Submission Form

Epping to Thornleigh Third Track Proposal. Application number SSI 5132.

Name(s): (DR) KEITH K. WATSON

Figure 5.6 Cross-section and elevation - New Cheltenham Station concourse building
Note: Indicatively added to future design

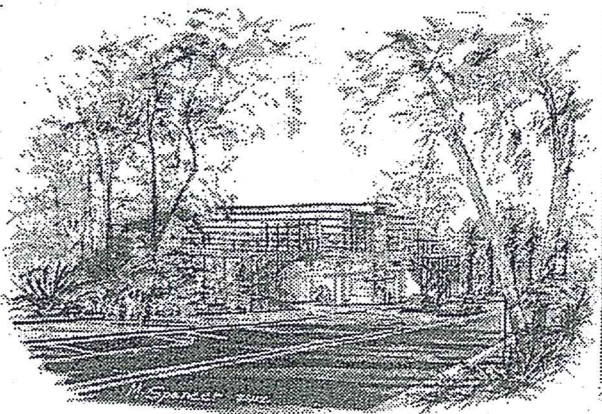
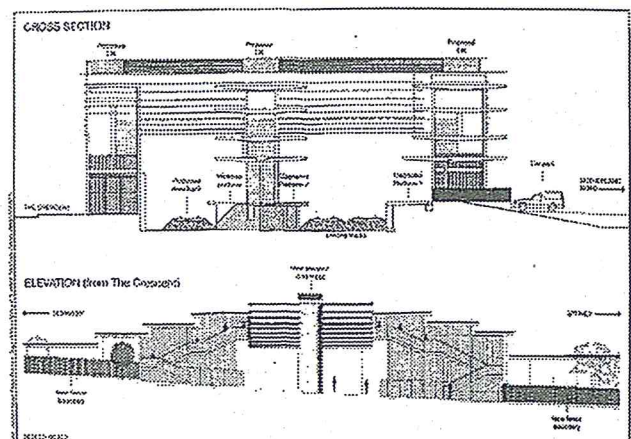
- The proposed redevelopment of Cheltenham Station shows no regard for the HCA. The visual impact of the proposed 13m high glass and steel concourse is totally unacceptable in this HCA.

Concept design drawing of proposed changes to Beecroft Station (Parsons Brinckerhoff 9/3/12). Former side platform shaded in pink.

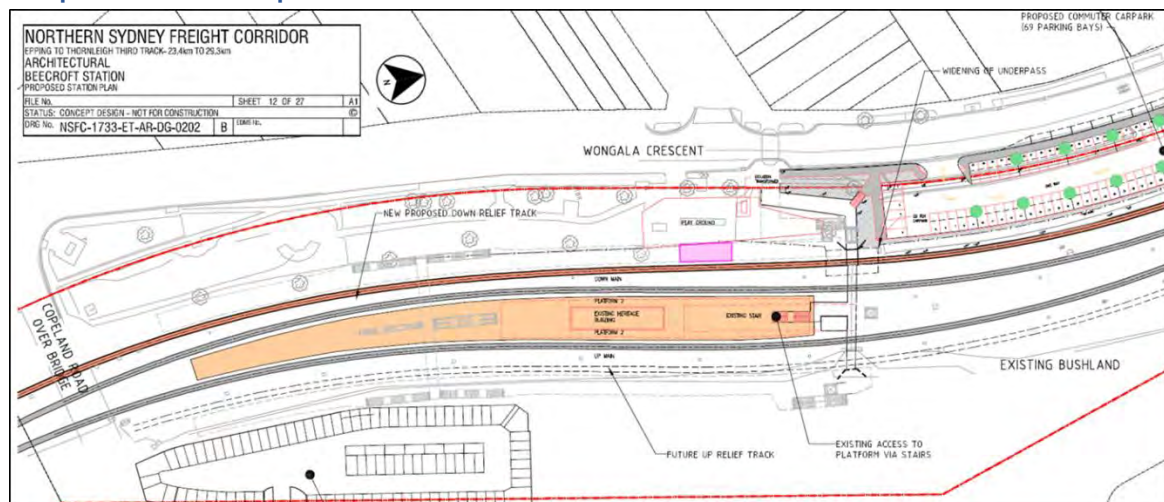
- There has been inadequate assessment of the project's impact on the fabric of the Beecroft Cheltenham Heritage Conservation Area (HCA).
- The plan given for Beecroft Railway station Precinct is vague. The relationship to the trees, playground and original 1895 platform located south of the present station is not shown. A fourth track is shown on the eastern side. The plan does not include urgently needed lifts to allow disabled access at Beecroft Station.

- Beecroft Station Gardens have a heritage listing with Hornsby Council but the impact on them has not been adequately addressed. No arborist's report is given for the trees which will be removed.
